Re: Status of Repair Application: EH2203-0016

Mark Osborne R.E.H.S.
Environmental Health Specialist
Harnett County Department of Public Health

Harnett County Department of Public Health Site Sketch

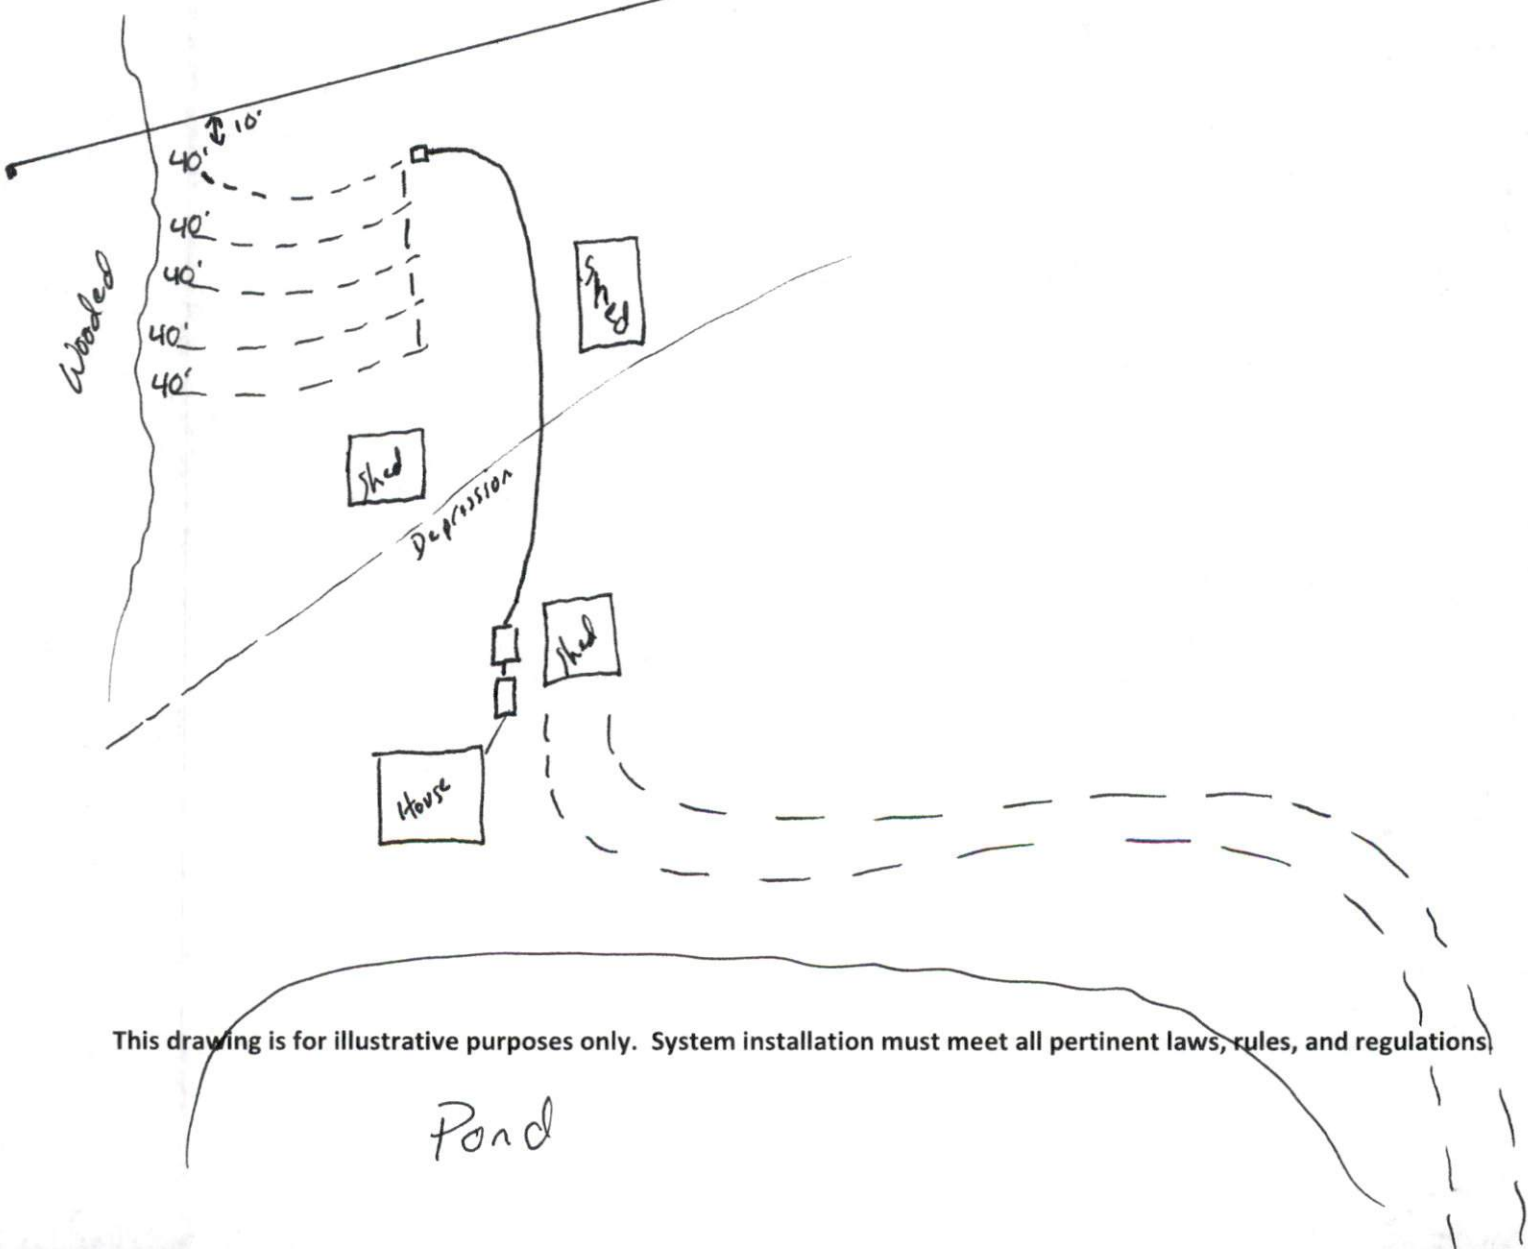
5. Driveway not shown on site plan (Revision Required)

7. Other- Locate all underground utilities
